City of Portland, Maine - Building or Use Permit Application
 389 Congress Street, 04101 Tel: (207) 874-8703, Fax: (207) 874-8716

Permit No: 10-0098	Issue Date:	CBL: 032 F003001
------------------------------	--------------------	----------------------------

Location of Construction: 30 Market St	Owner Name: E L C Inc	Owner Address: 42 Market St	Phone:
Business Name:	Contractor Name: Eastern Fire Protection Co., Inc.	Contractor Address: 170 Kittyhawk Ave., PO Box0139 Aubu	Phone 2077841507
Lessee/Buyer's Name	Phone:	Permit Type: Fire Suppression System	Zone:

Past Use: Commercial - Restaurant - "Pat's Pizza - Old Port" (tenant fit up permit #10-0102)	Proposed Use: Commercial / Restaurant - Fire Suppression System	Permit Fee: \$120.00	Cost of Work: \$10,000.00	CEO District: 1
		FIRE DEPT: <input type="checkbox"/> Approved <input type="checkbox"/> Denied		INSPECTION: Use Group: Type
Proposed Project Description: Fire Suppression System		Signature:		Signature:
		PEDESTRIAN ACTIVITIES DISTRICT (P.A.D.) Action <input type="checkbox"/> Approved <input type="checkbox"/> Approved w/Condition <input type="checkbox"/> Denied Signature: Date:

EXISTING ELEVATION
SCALE: 1/4"=1'-0"

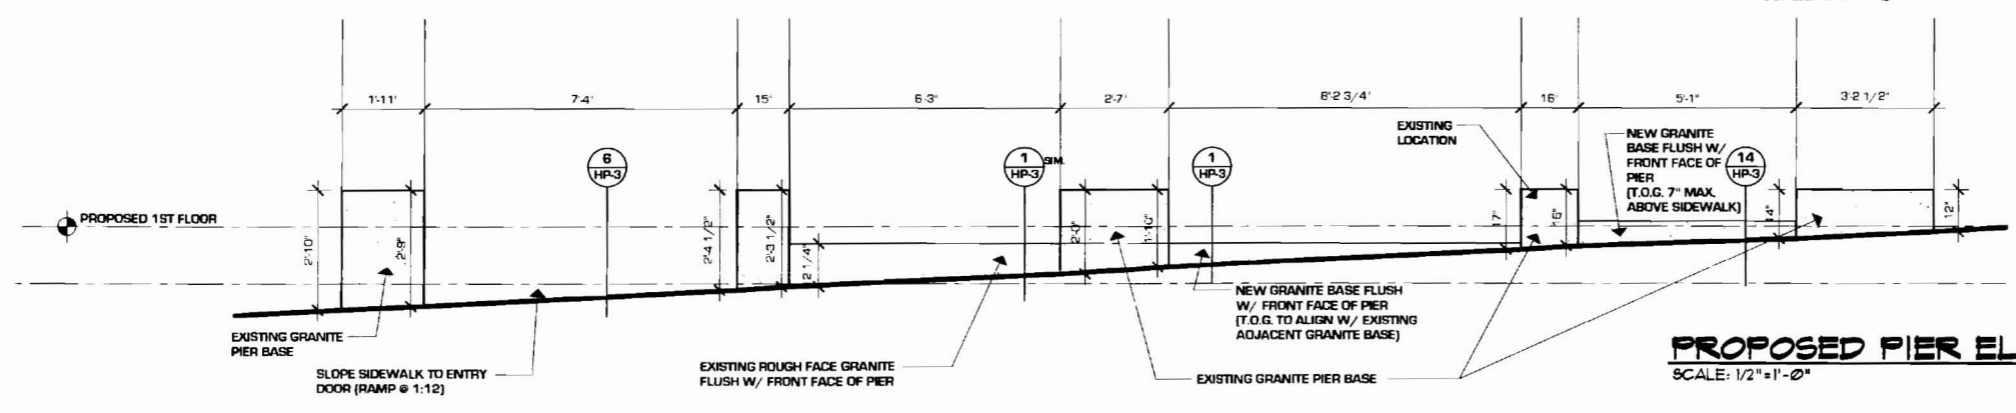
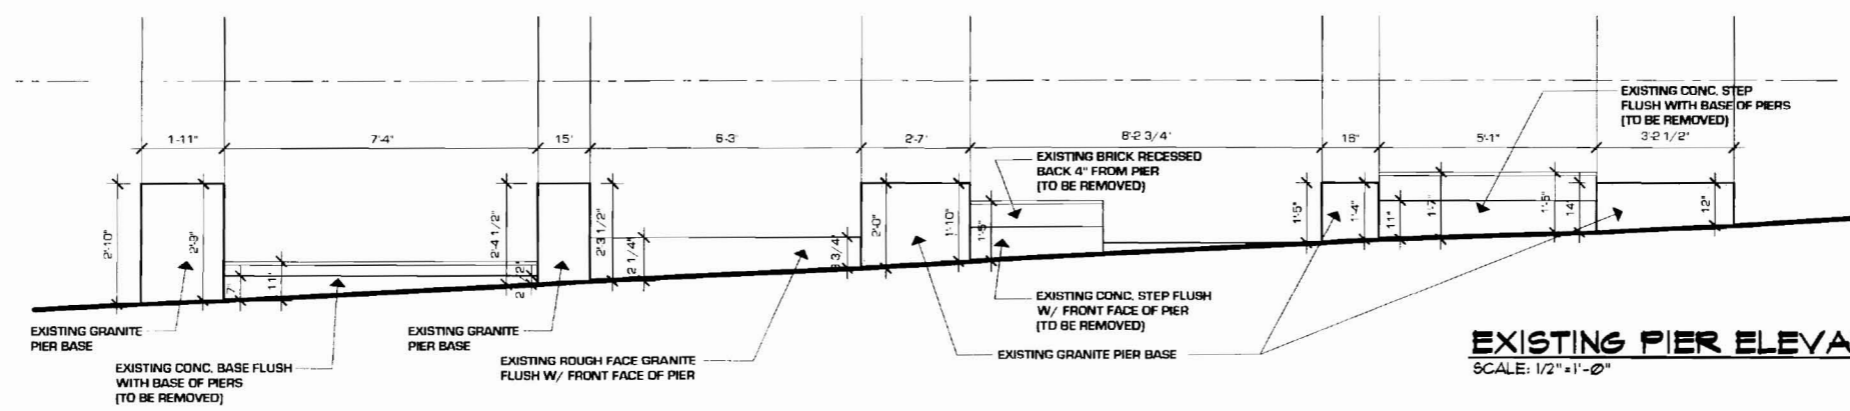
- 1) * Only the fire department hose connection may be installed on the front facade. All other exterior components associated with fire sprinkler system, including sprinkler gong and main drain, to be located on rear elevation, outside of public view.
